Historic England

**NEW MILLS, BROUGHAM ROAD, MARSDEN, HUDDERSFIELD, HD7 6AZ
Application No. 2026/62/90232/W**

Thank you for your letter of 21 April 2026 regarding the above application for planning permission. On the basis of the information available to date, we offer the following advice to assist your authority in determining the application.

**WEST MILL INDICATIVE FLOOR PLANS**

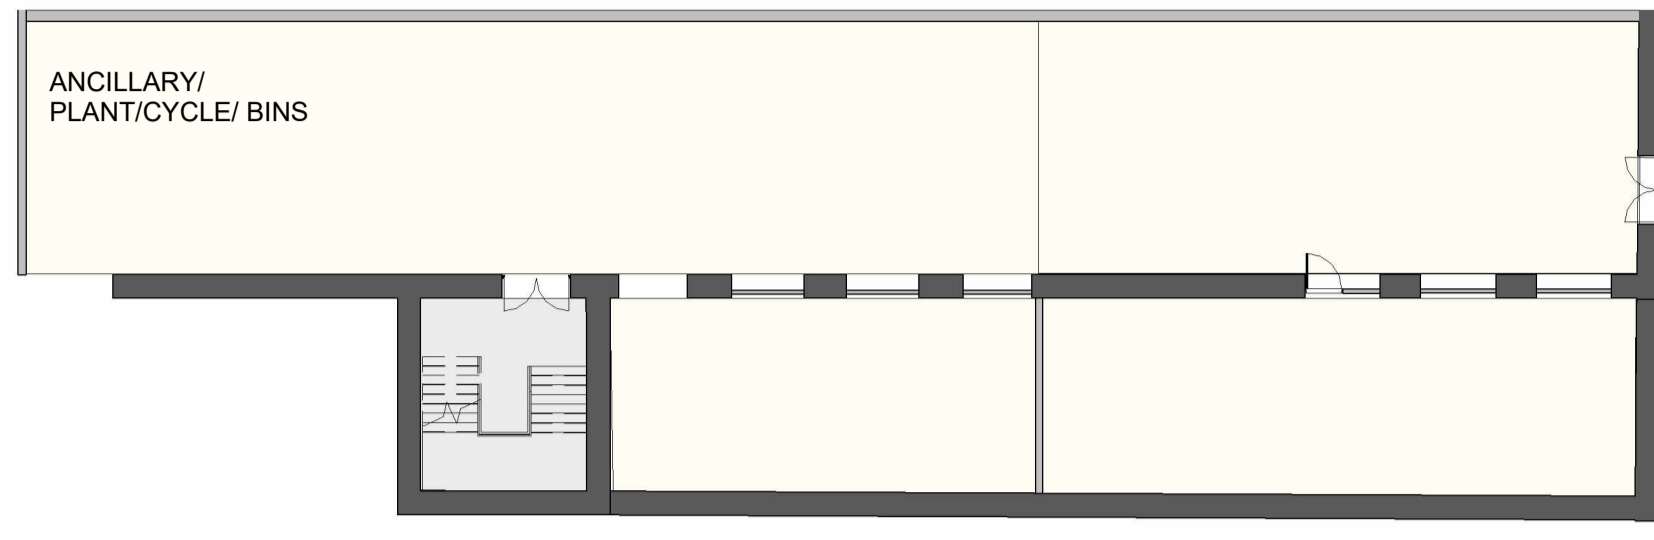
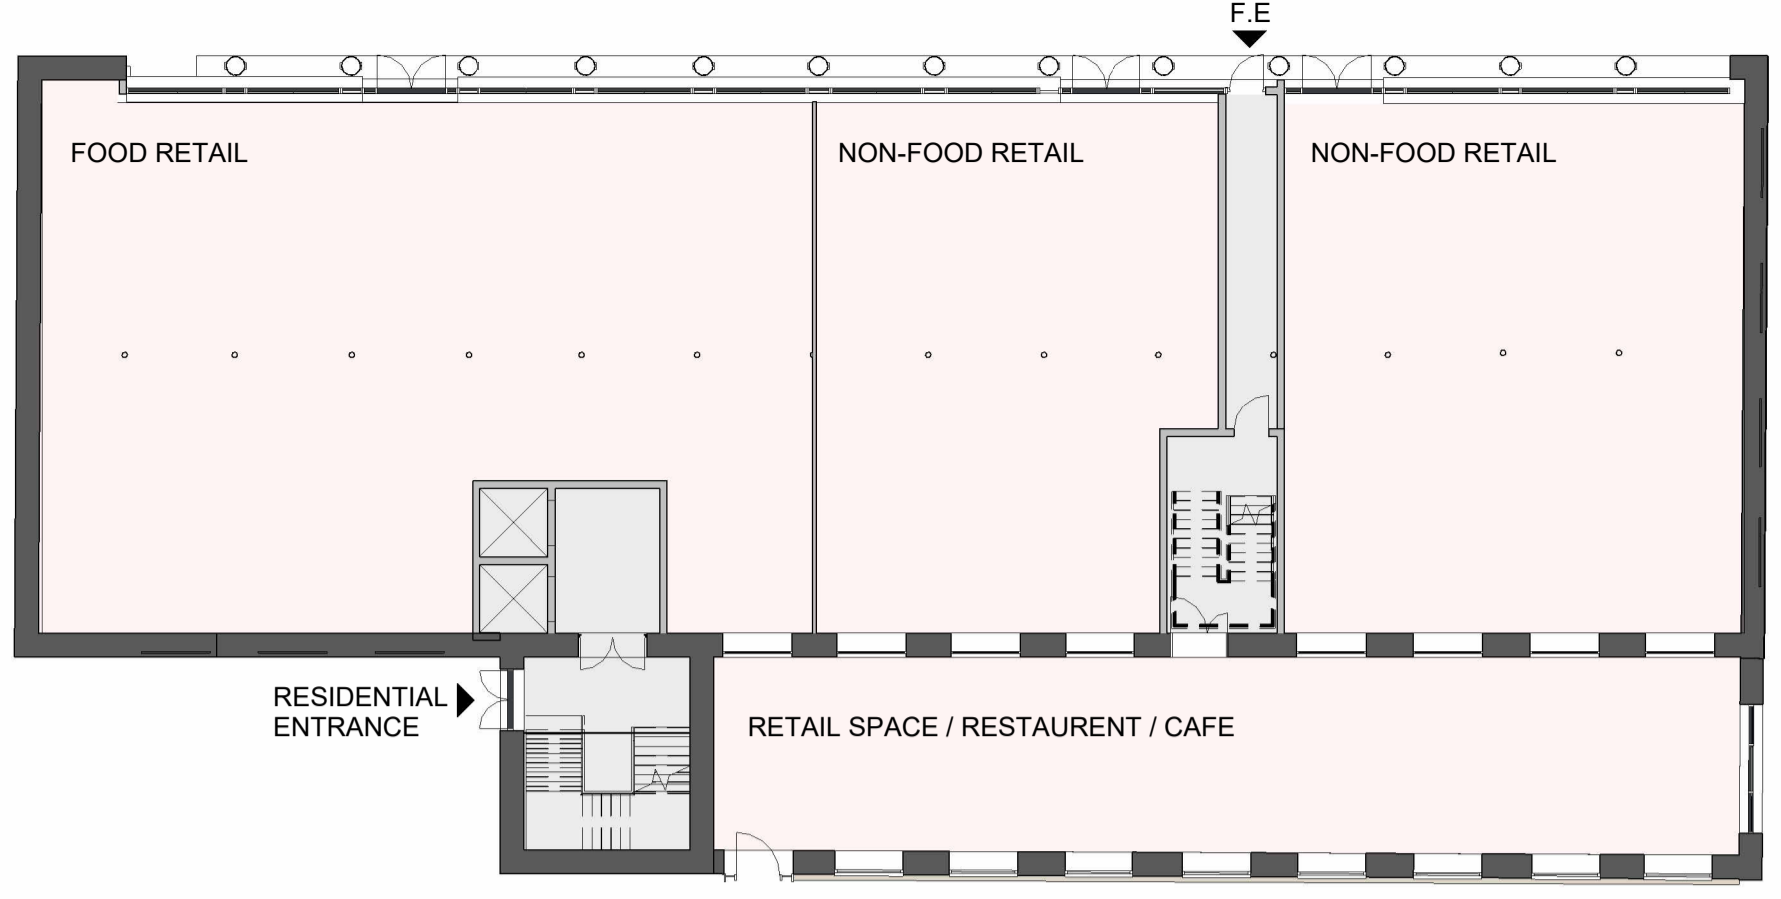
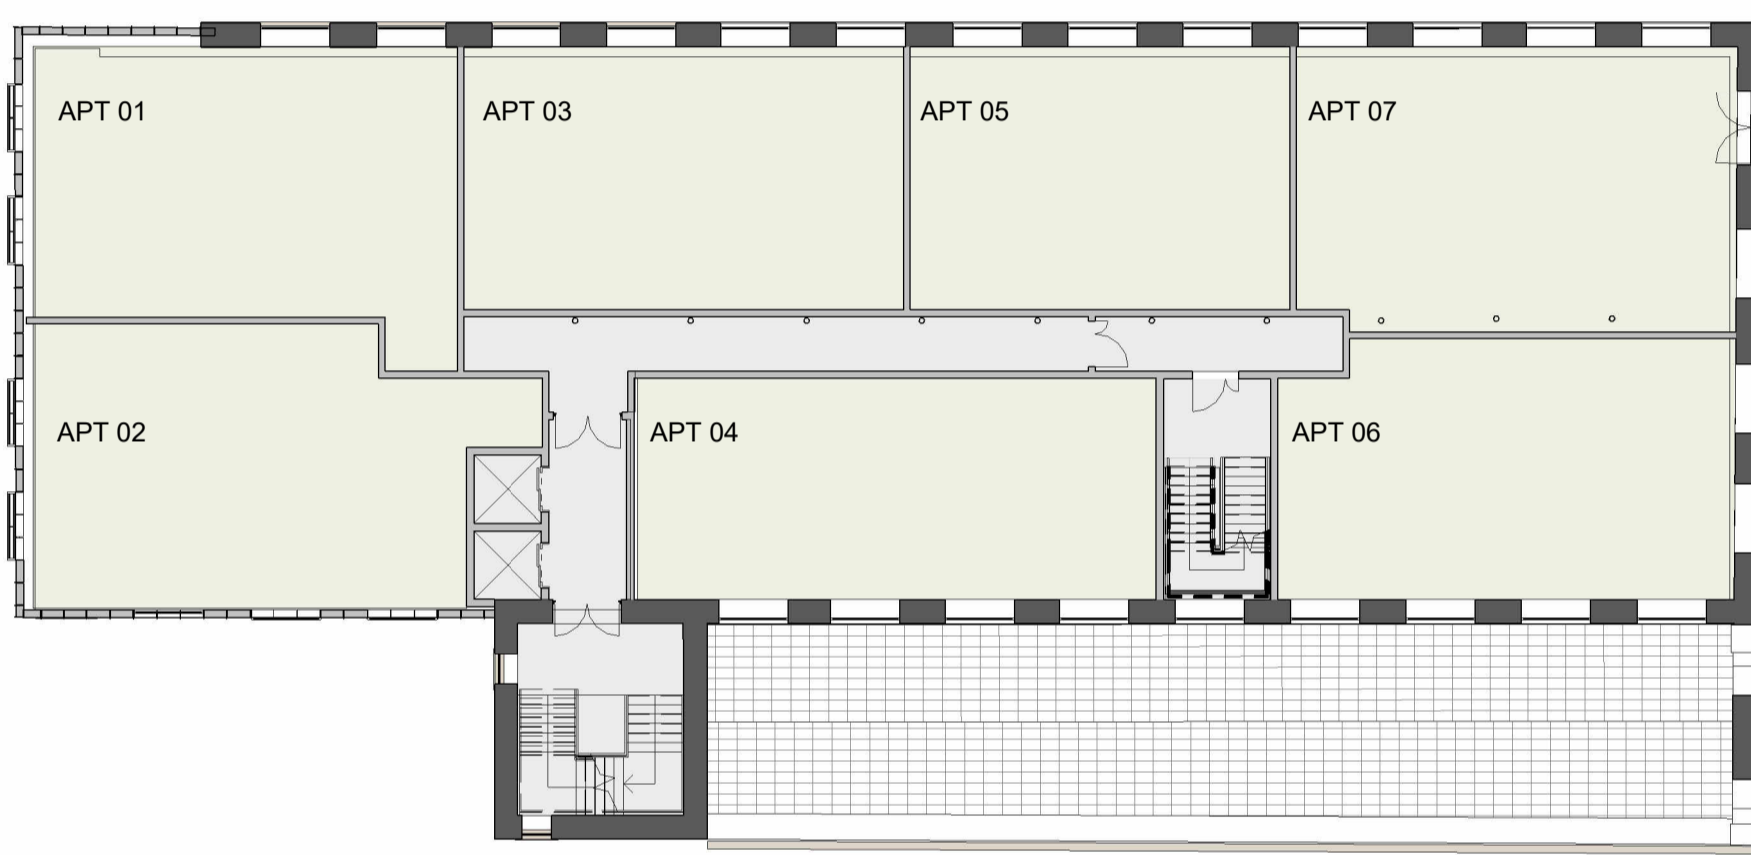
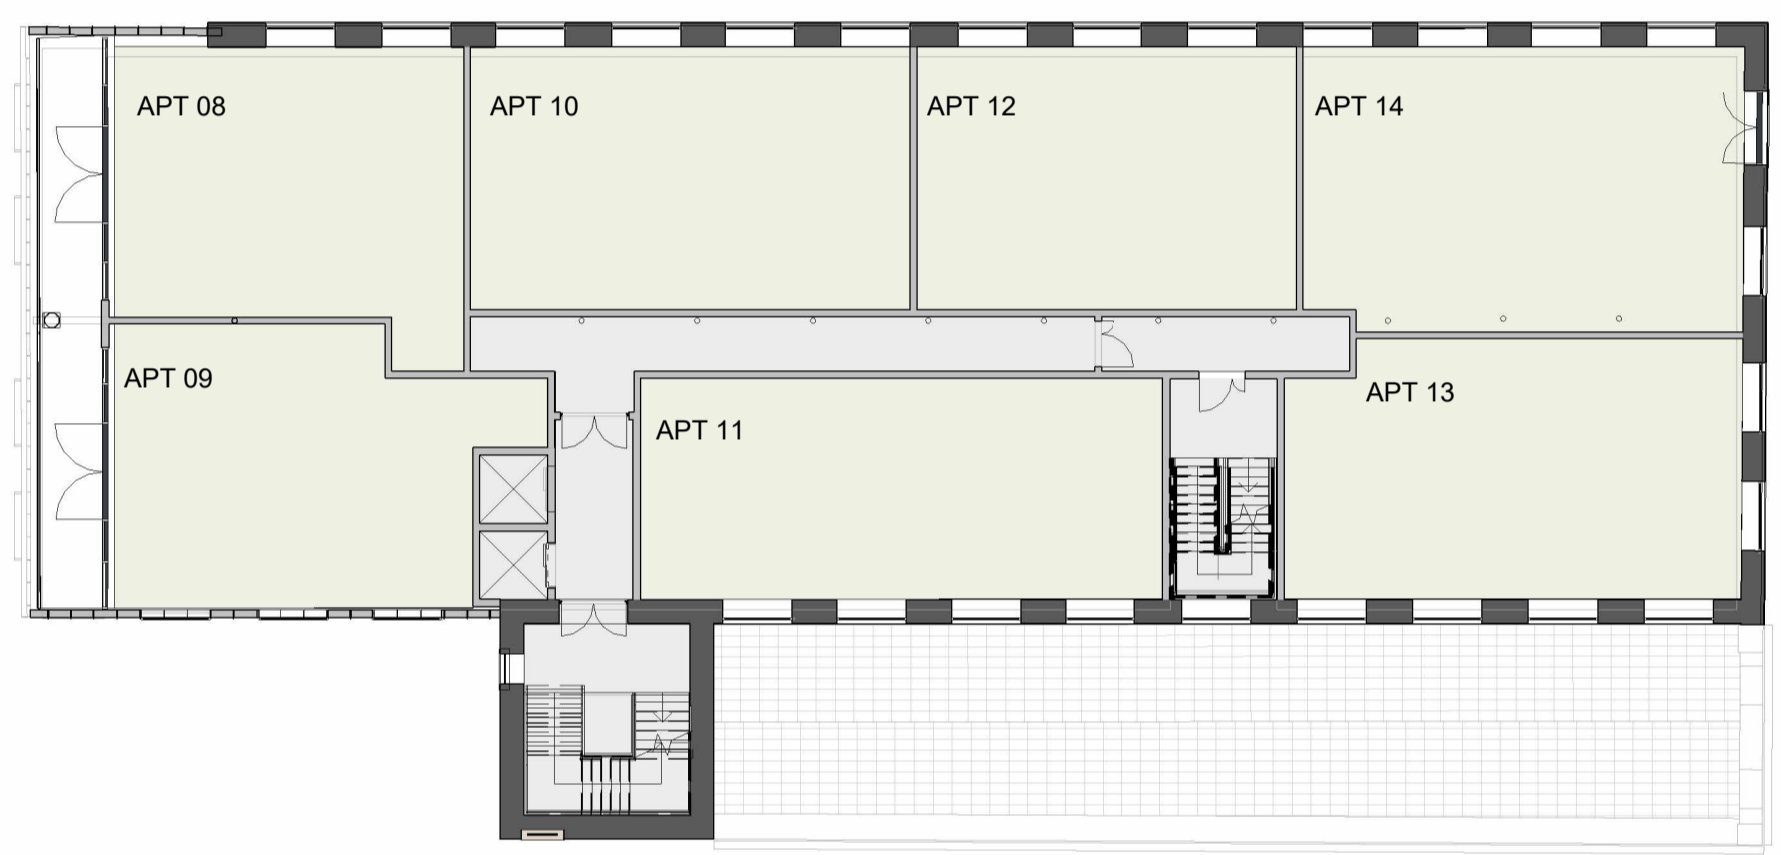
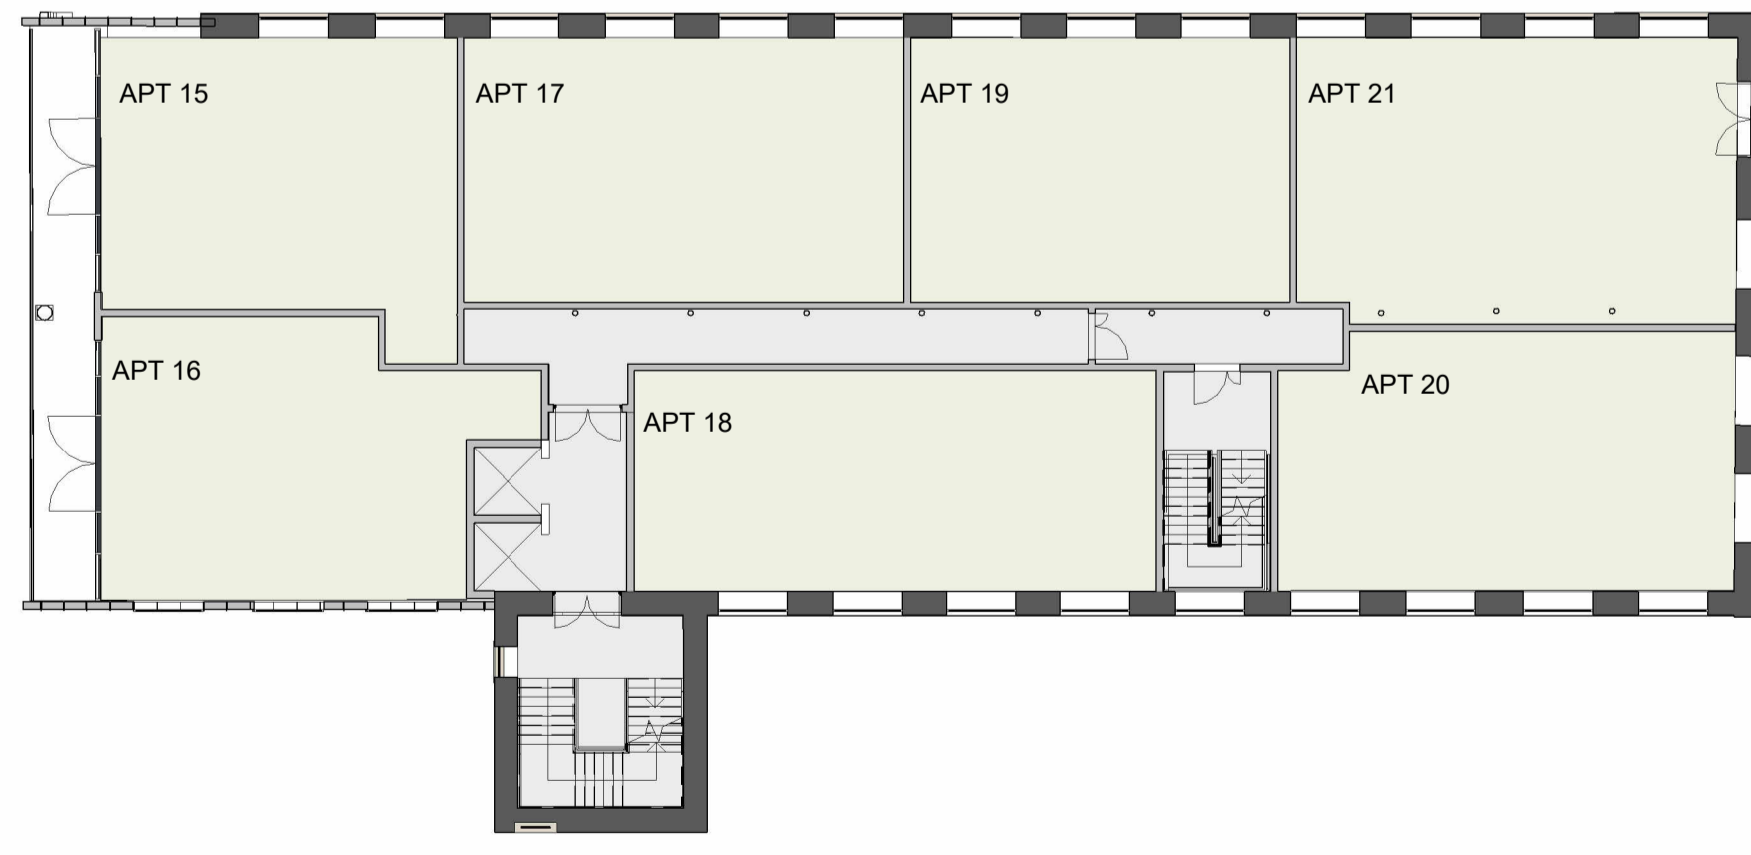
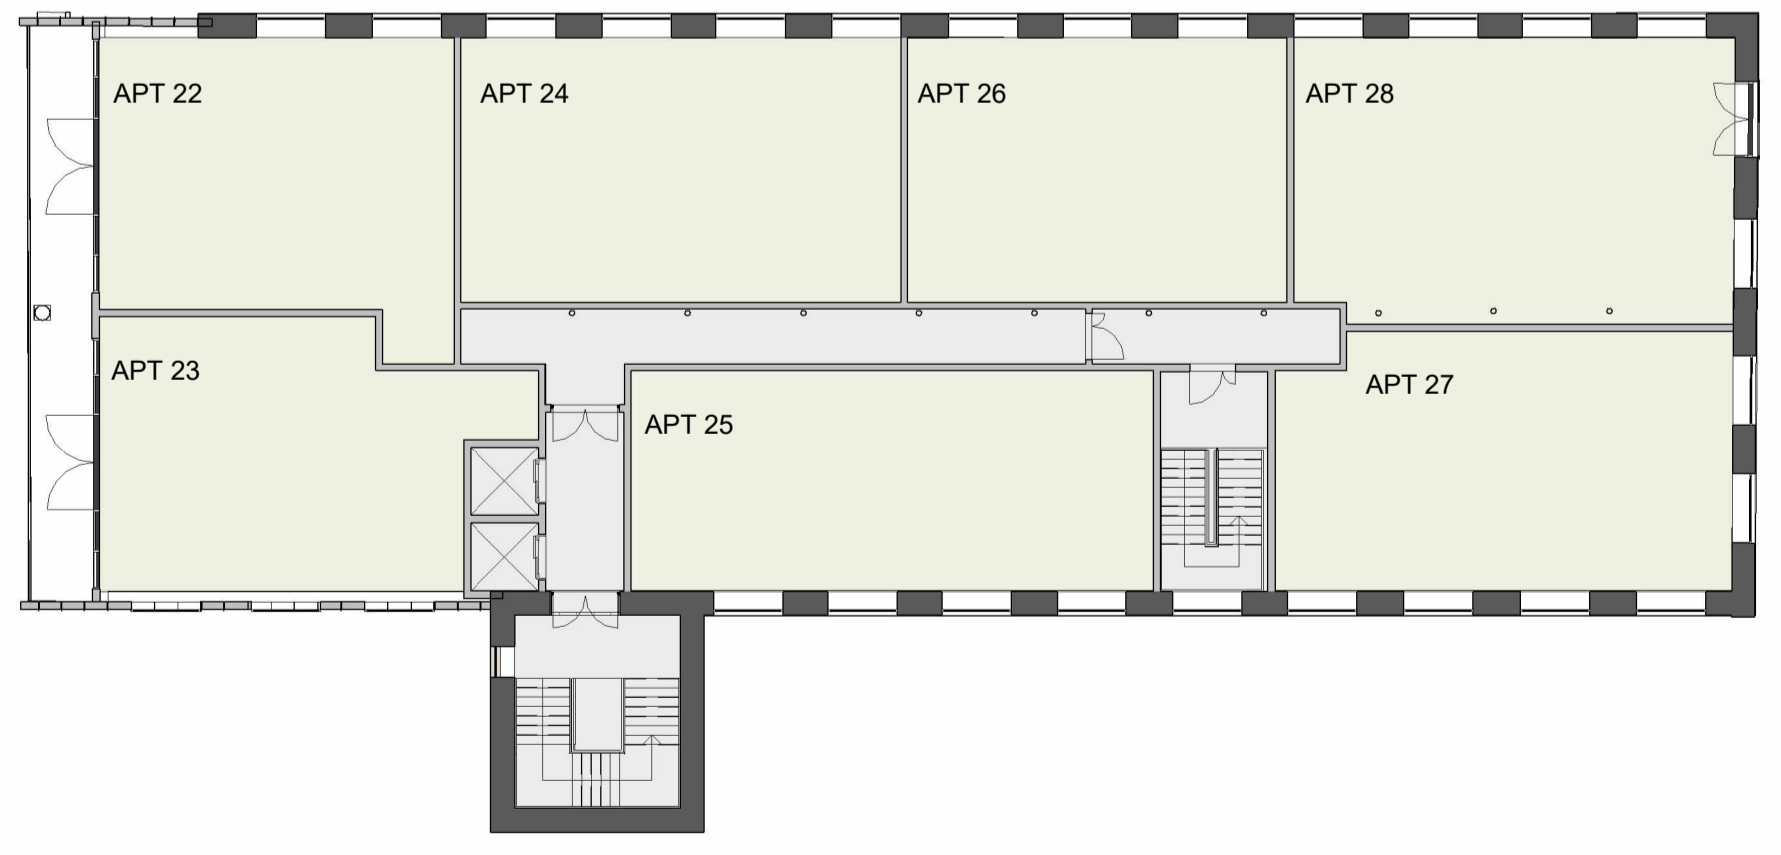
The proposals to demolish approximately a third of the West Mill would cause a medium amount of less than substantial harm to the significance of the conservation area. This is because the mass and landmark character of the West Mill would be impinged, including the loss of the more politely detailed office block facing onto Brougham Road.

The inclusion of a small-scale facade retention of the office block on Brougham Road would at least preserve the building line and some of the finer detailing of the offices which would minimally reduce the above harm.

The proposed work to regularise the new gable end of the West Mill is contemporary in appearance and is considered to have a neutral impact upon the significance of the conservation area.
